Online Comment

Application H18-0671-19
Location 36 PETTS LANE SUTTON BRIDGE SPALDING PE12 9QB
Proposal Extension and alterations of existing house. Existing outbuilding to be converted into annexe and buildings linked together with a link building

Name Gregory Watkinson, Conservation Officer
Address C/O South Holland District Council Council Offices

Date Submitted 21-08-19
For/Against Objections

PROPOSED HOUSE PLANS

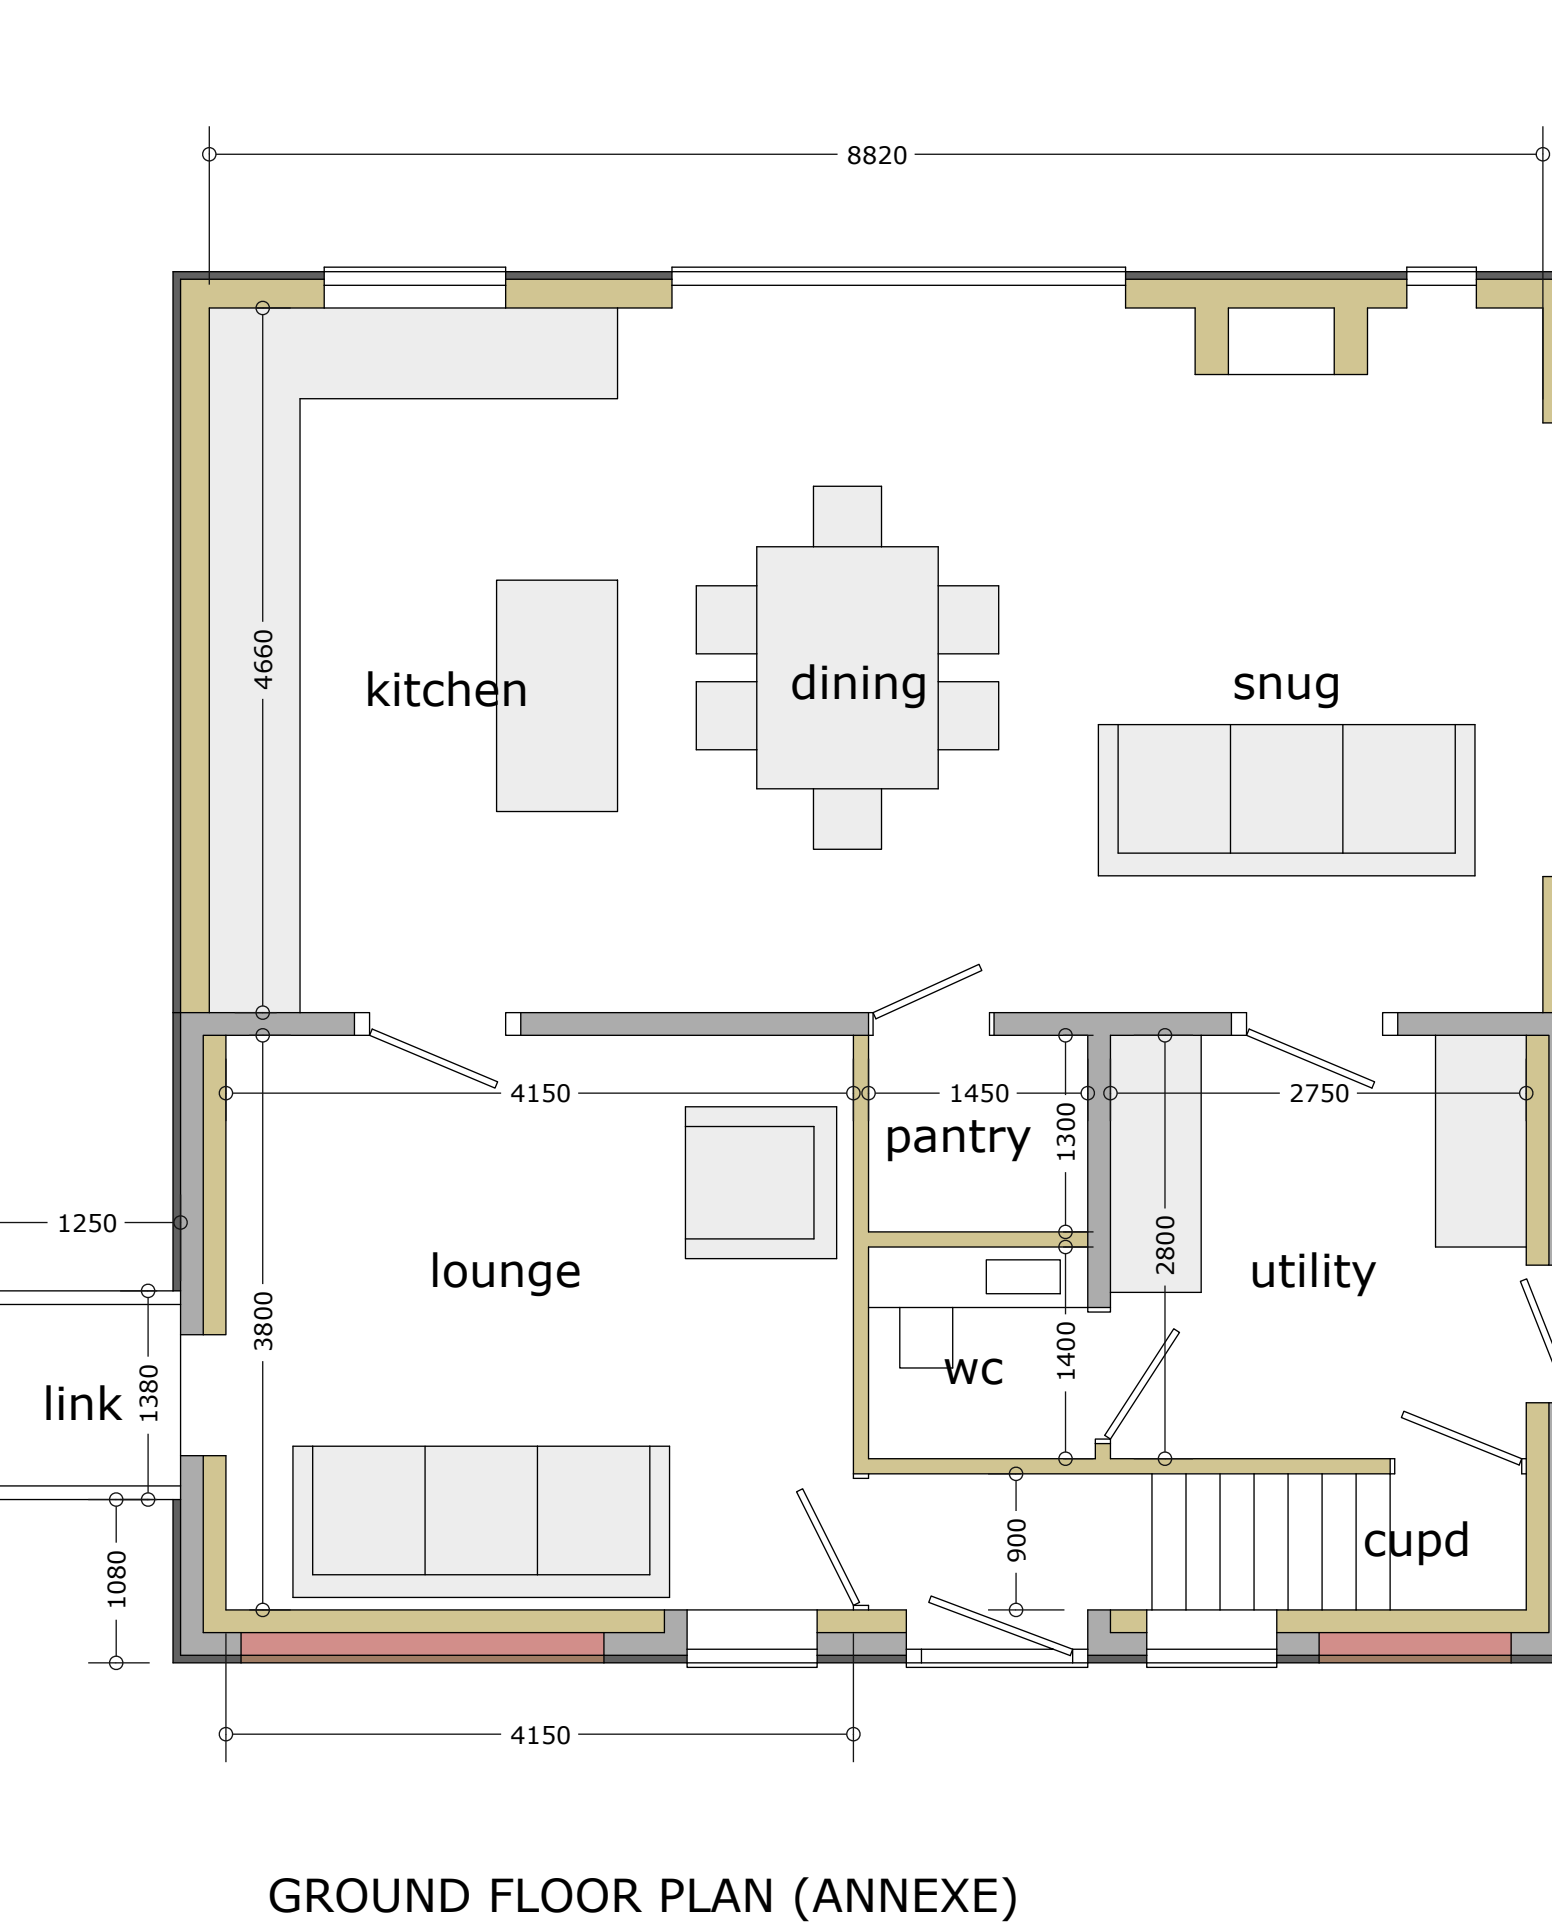
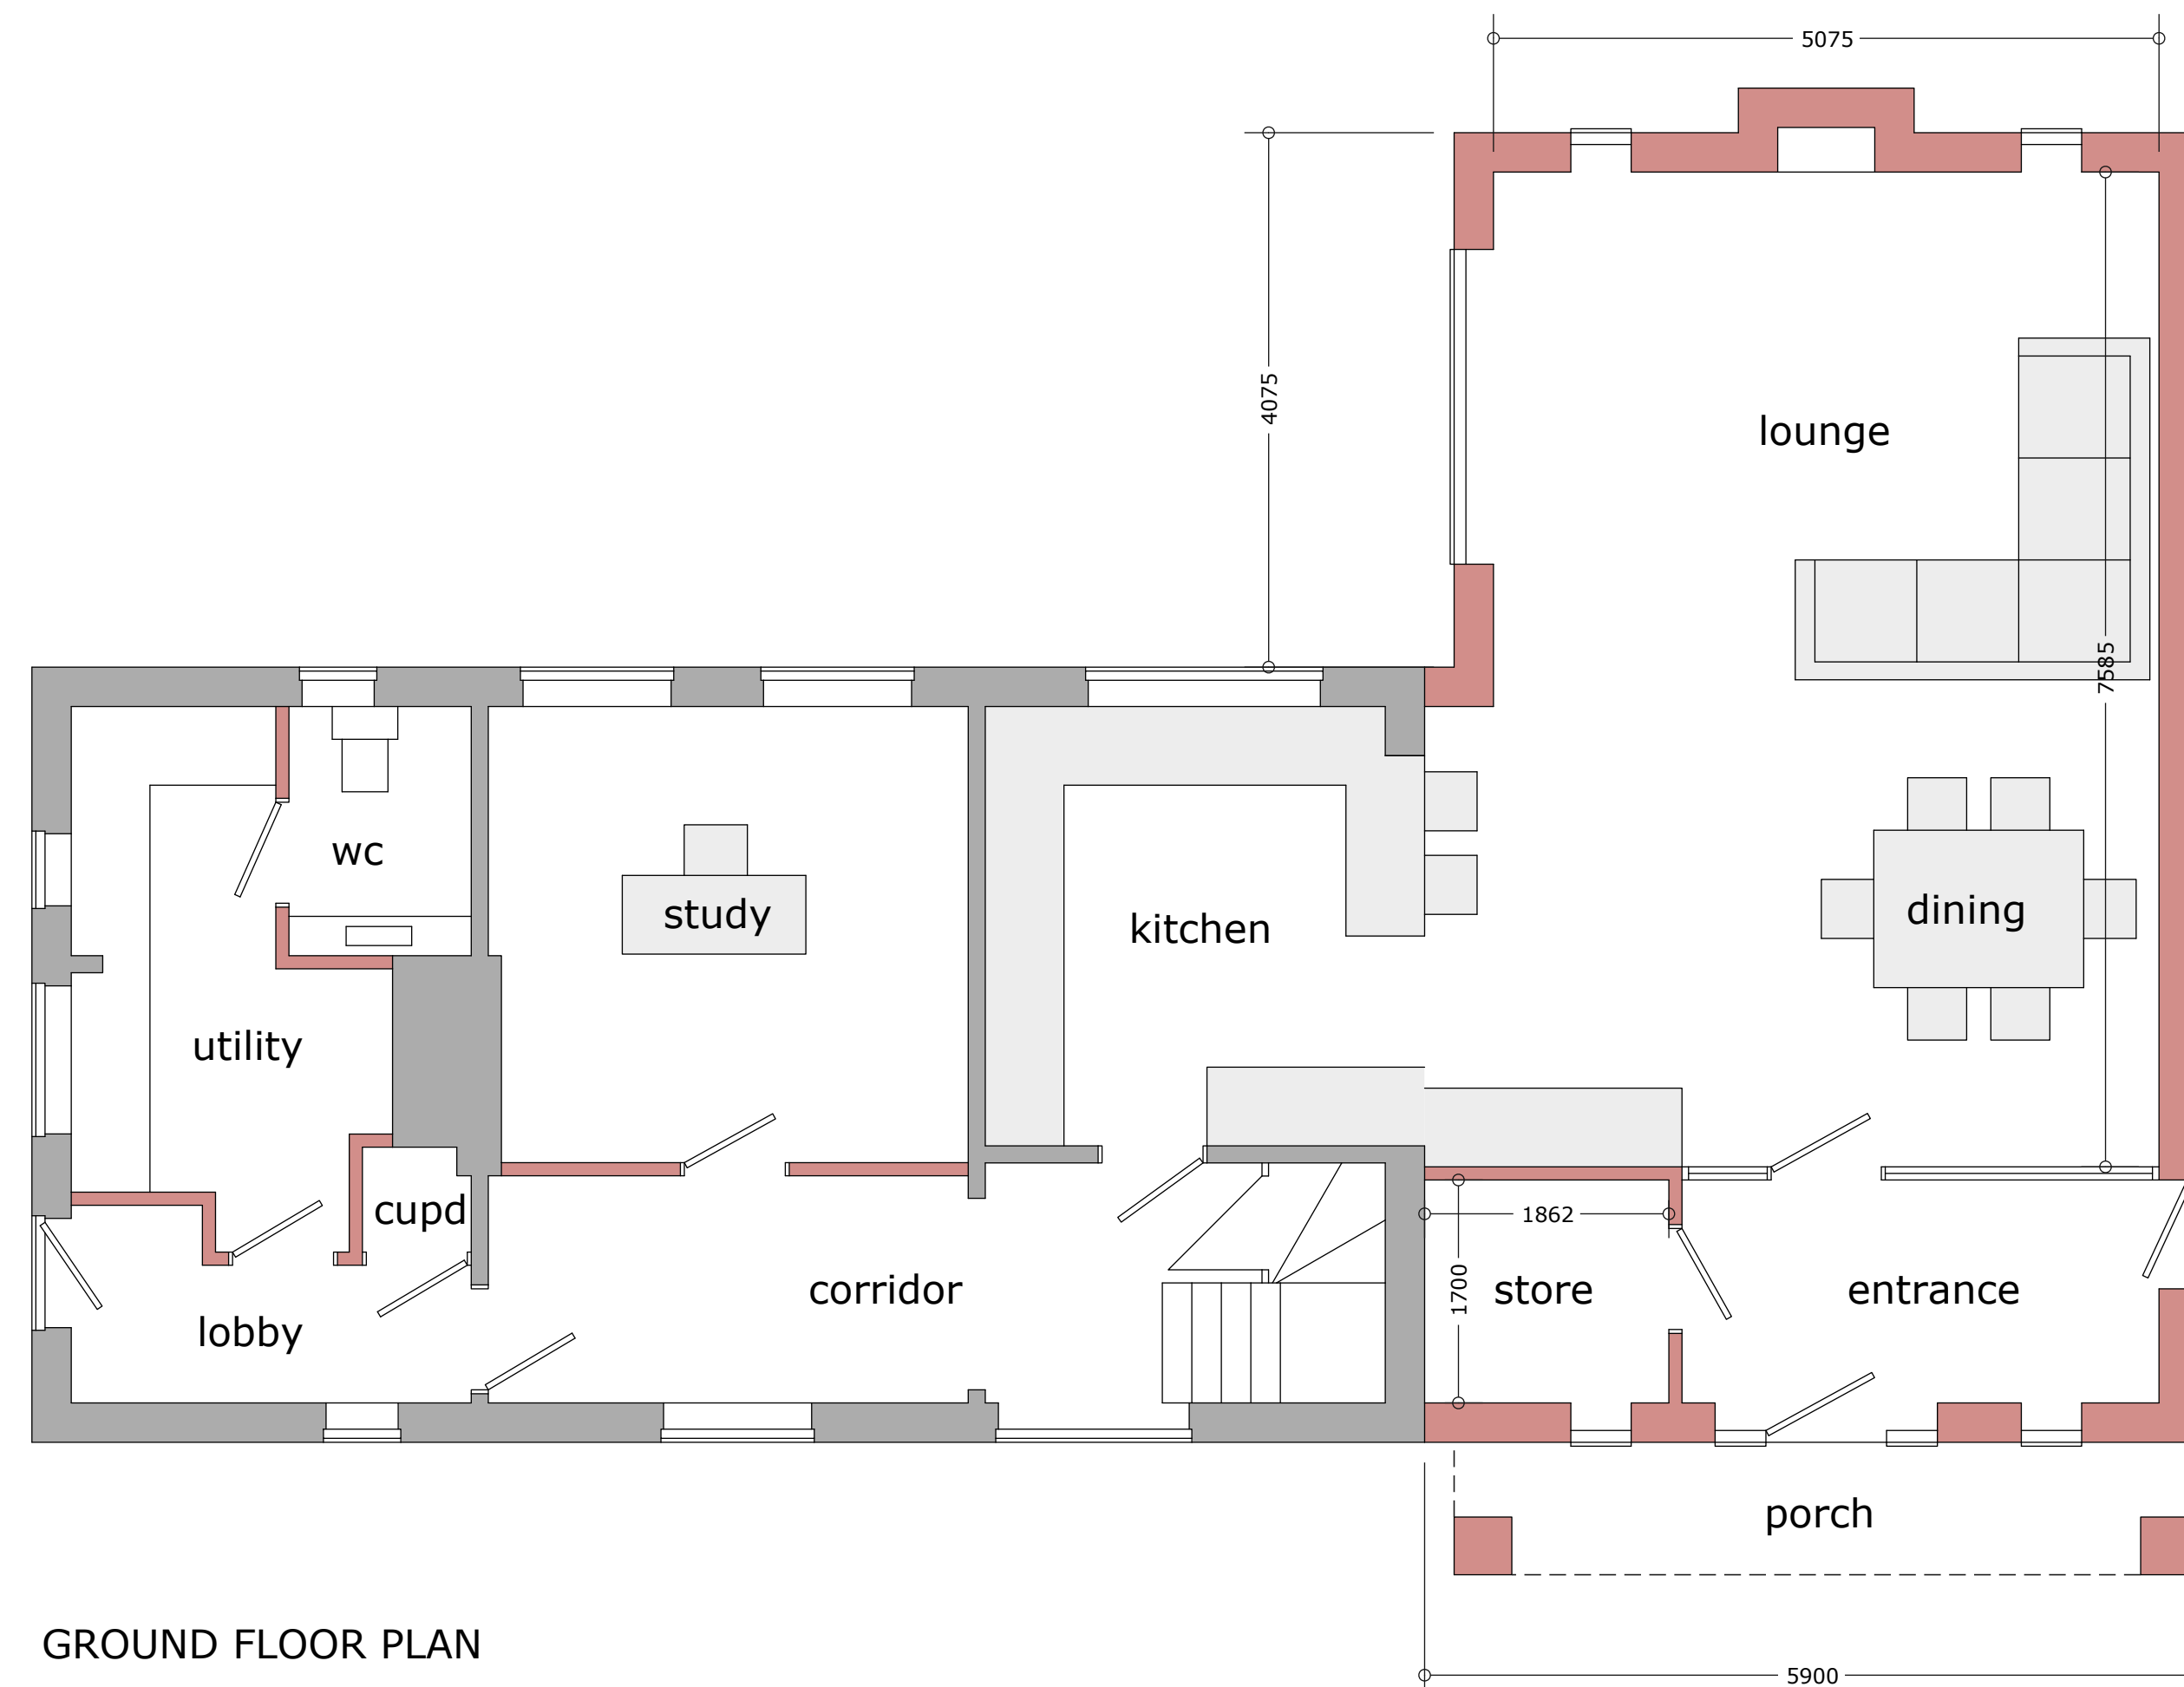
Whilst I do not have an issue with the principle of extending this property, the current plans propose works which would heavily modify the original property and would diminish it into appearing as a wing of a more modern structure. This coupled with the reordering and replacement of windows and doors and the removal of a pair of chimneys would mean the proposals would not be in sympathy with the site's history, rural location or agricultural character.
